CITY OF ALBUQUERQUE
PLANNING DEPARTMENT
DEVELOPMENT REVIEW BOARD

Project# 1007316

11DRB-70284 SITE DEVELOPMENT PLAN FOR BUILDING PERMIT
11DRB-70303 MINOR - PRELIMINARY/ FINAL PLAT APPROVAL

SITE PLAN - PHASE 2 (FULL BUILD-OUT)
1" = 50'-0"

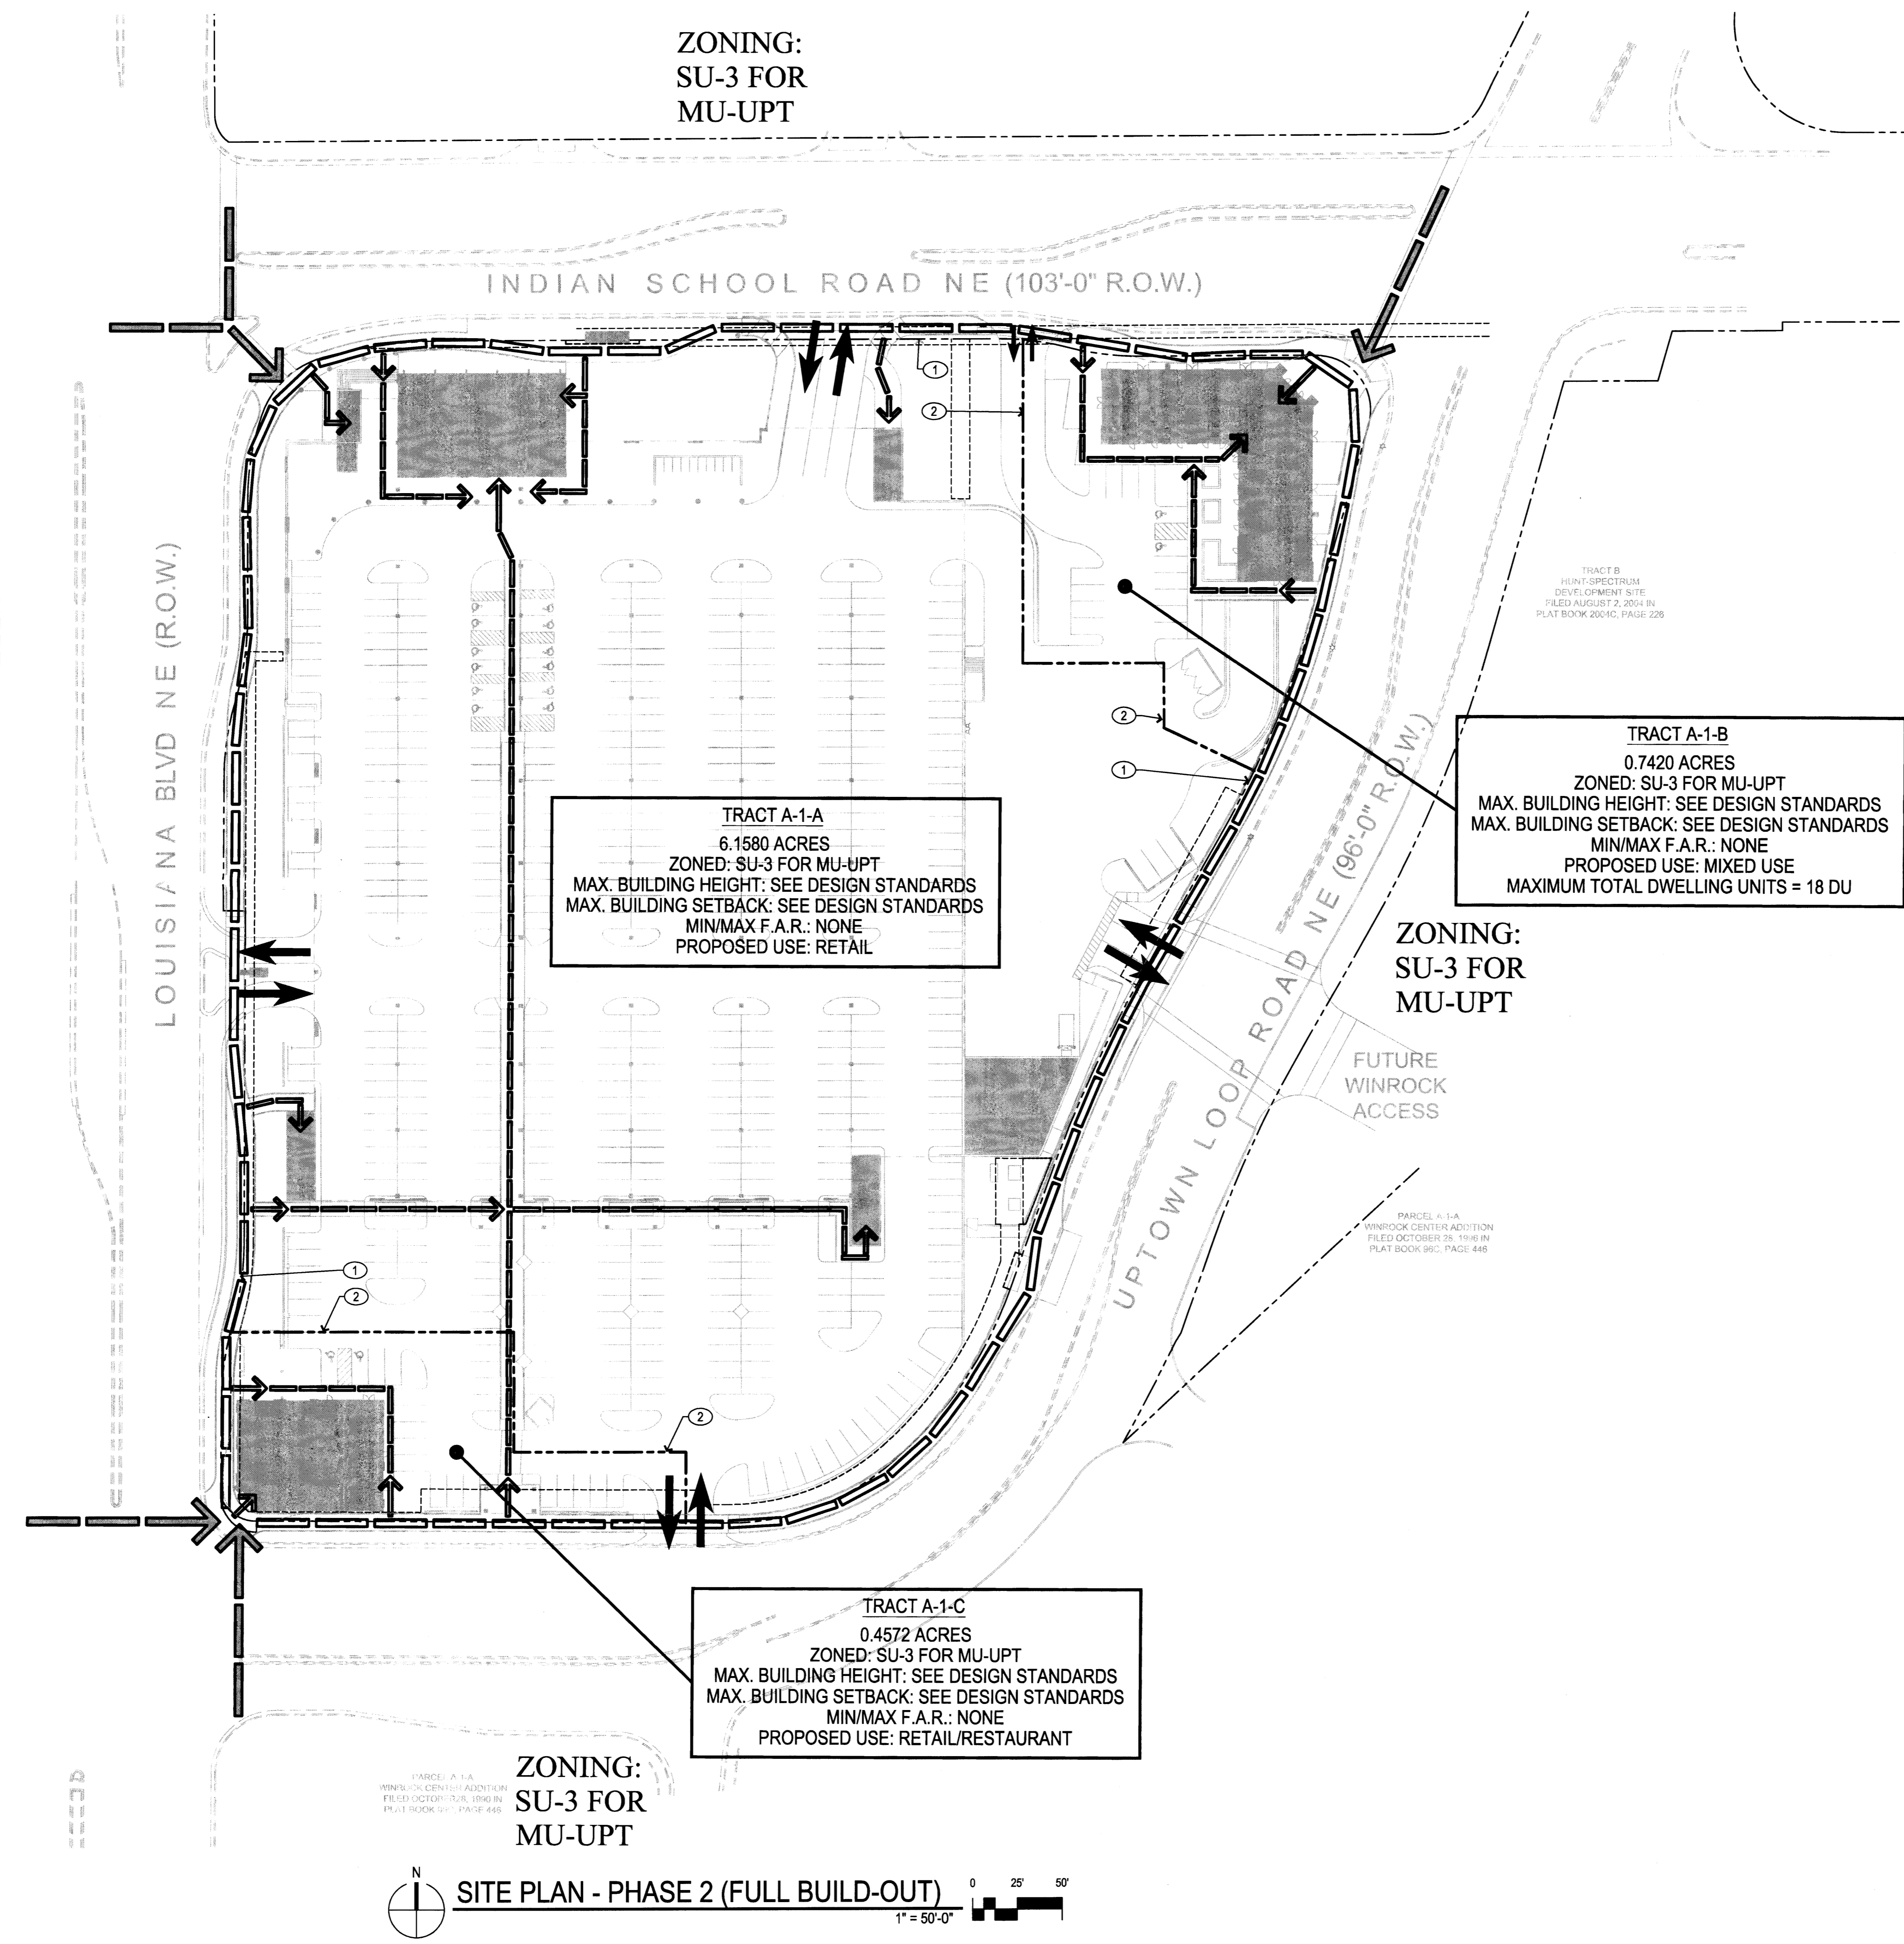
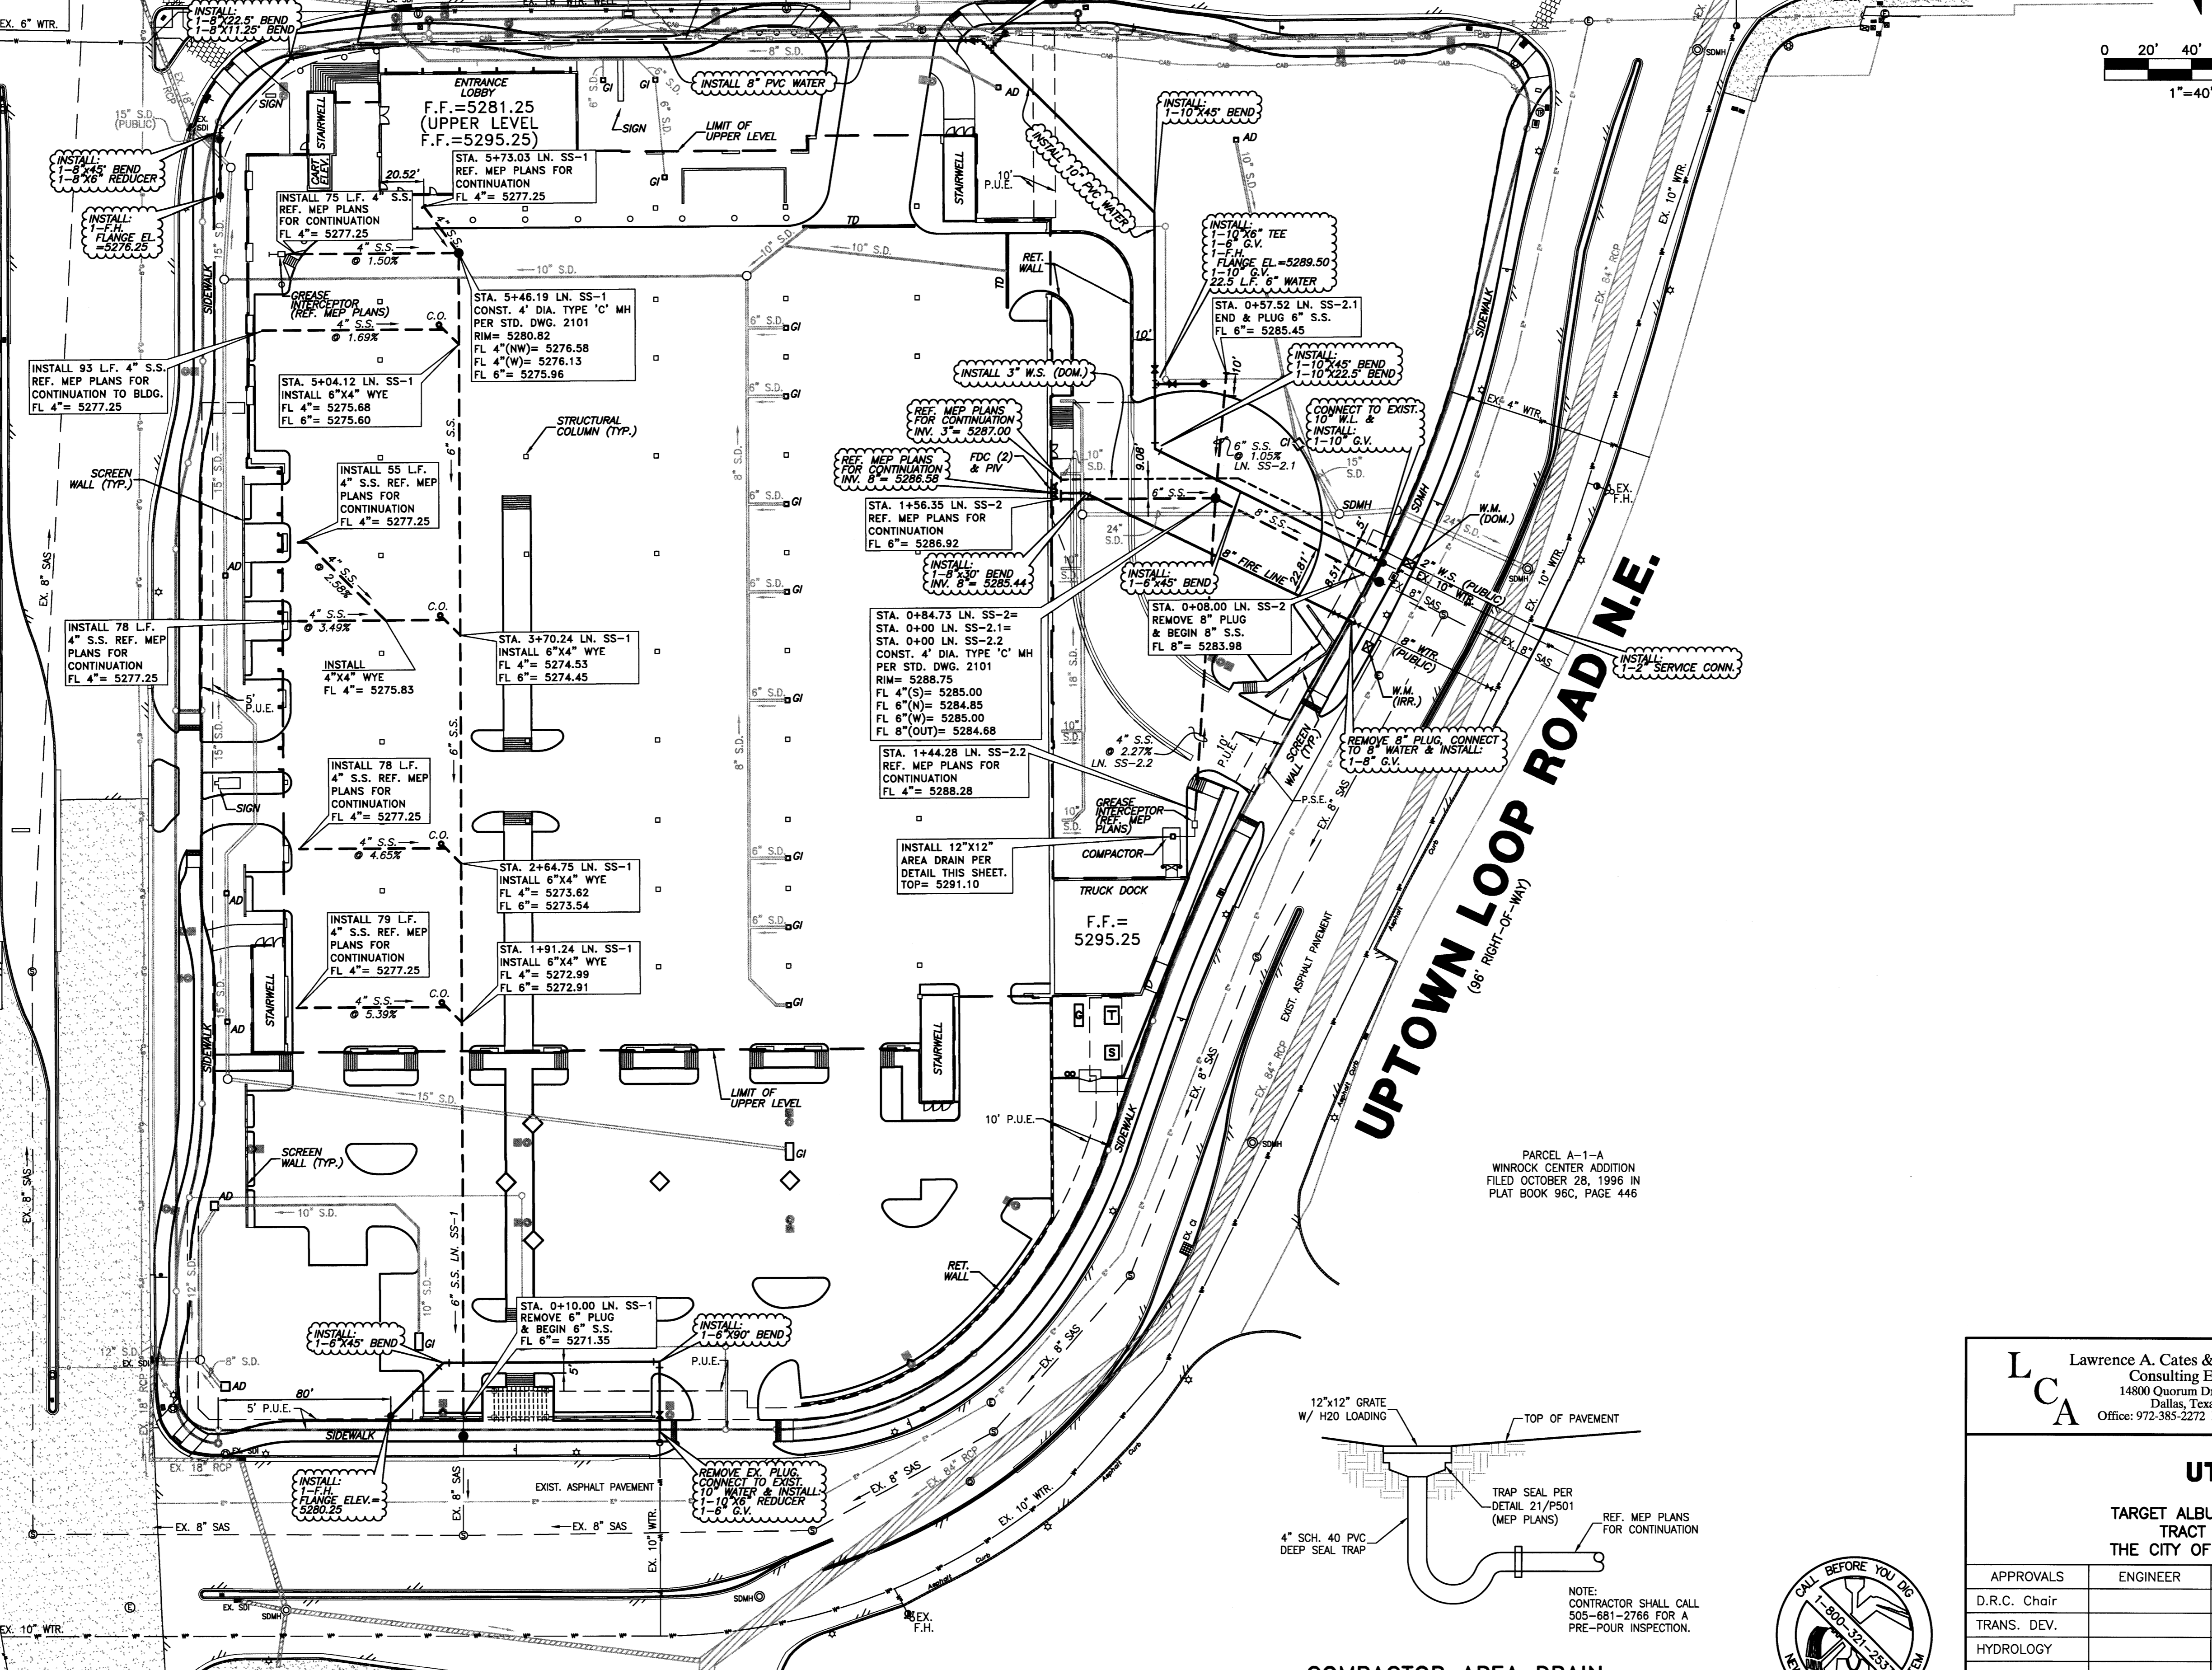
1. The pedestrian linkage in the parking lot on the south of Building 1 shall have a flared/ split concrete connection to the public sidewalk on the Uptown Loop Road, to direct pedestrians west or east.
2. A contrasting color (and/ or material) shall be used as a major façade change over the new vehicular access on the east elevation.
3. An informational note shall be provided regarding care for delivery allocation to minimize semi-trailer conflicts with vehicular customer traffic.
